**Consultation Response from KC,
Highways Development Management**

2026/90312 Caravan at, Malvern Lodge, 10, Old Hall Road, Upper Batley, Batley, WF17 0AX

Erection of detached dwelling (within a Conservation Area)

Date Responded: 28 April 2026

Drwg. No: 0611_OLD_103

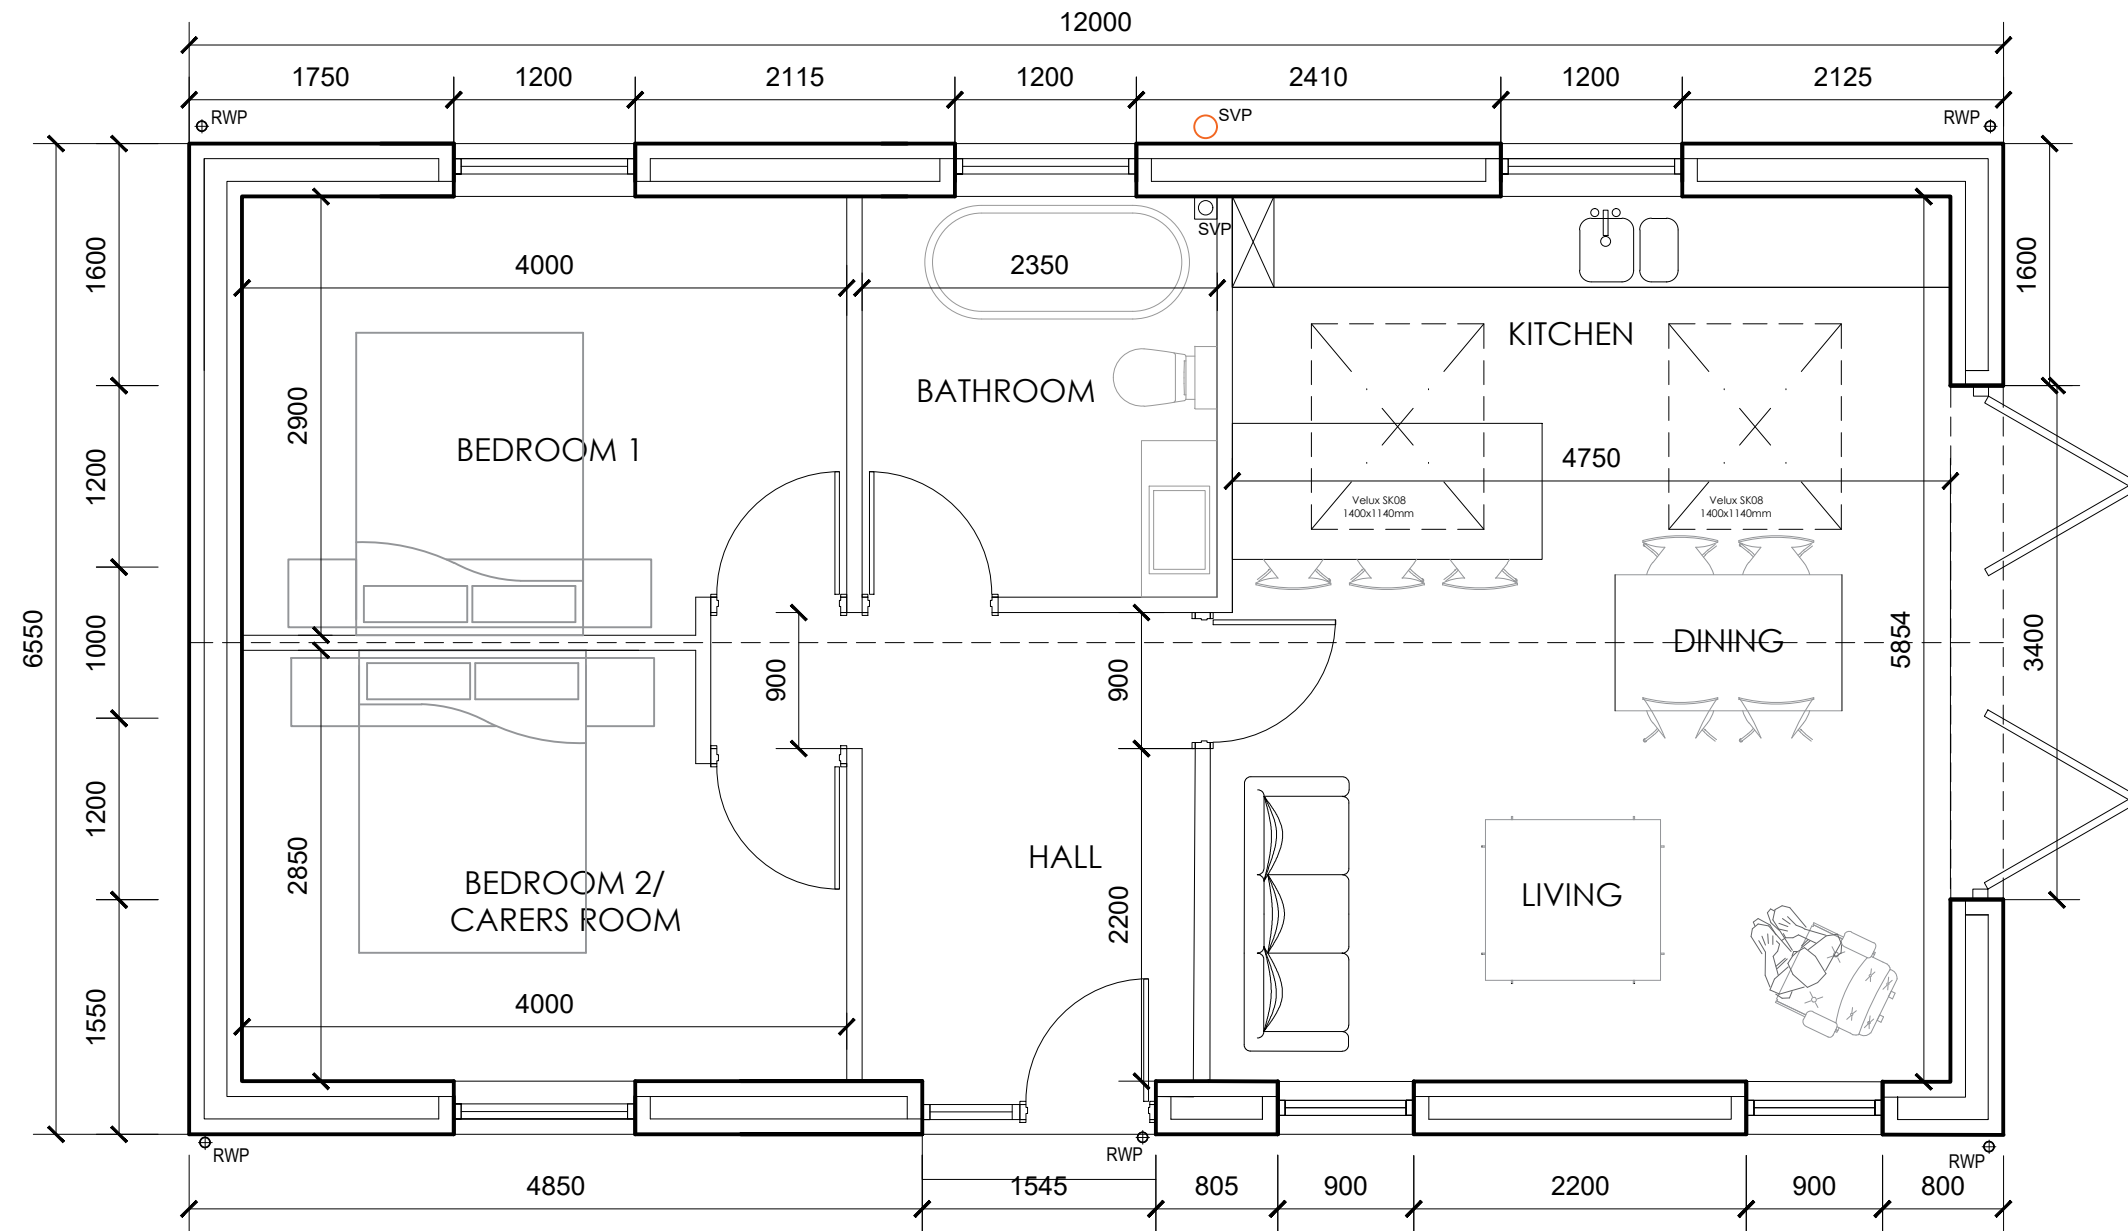
HDM notes the replacement of a static caravan by a two bedroomed detached dwelling within the grounds of Malvern Lodge, 10 Old Hall Road.

Drwg. No: **0611_OLD_102**

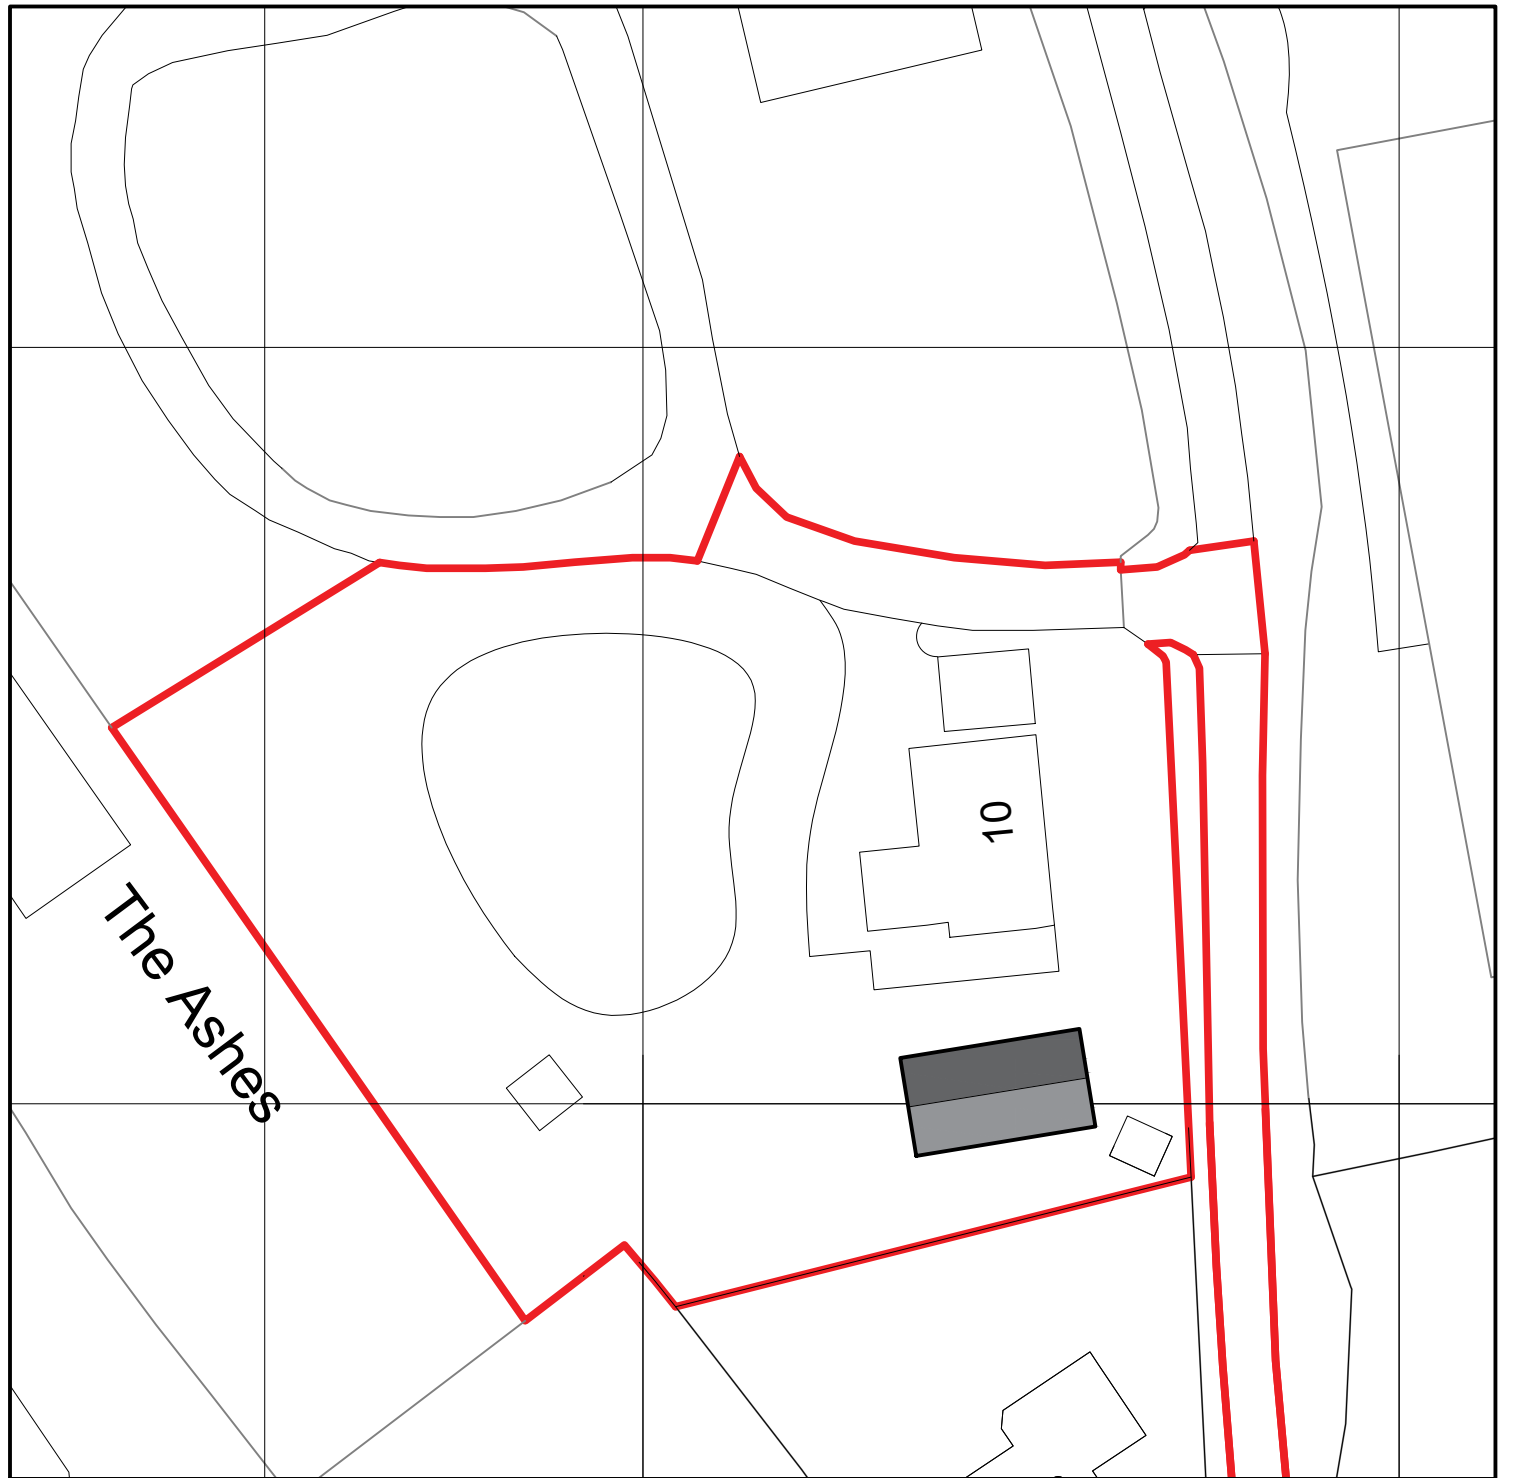
The proposal retains access from Old Hall Road an unadopted, single carriageway width, shared surface street as well as sharing the parking and turning area as well as bin storage with Malvern Lodge. The amount of parking would continue to be suitable with ample space to cater for Malvern Lodge and the proposed new dwelling on the proposed unit remaining ancillary to the main dwelling. Three parking spaces being the advised norm to serve four plus bedrooms from the Kirklees Highway Design Guide SPD.

The proposal does not raise significant issues for road safety or network functionality with movements expected to be like the existing caravan use. Accordingly, no objection is raised subject to a request for a planning condition for the proposed unit to be ancillary to the host dwelling:

The building hereby permitted shall not be occupied at any time other than for purposes ancillary to the residential use of the dwelling known as Malvern Lodge, 10 Old Hall Road.
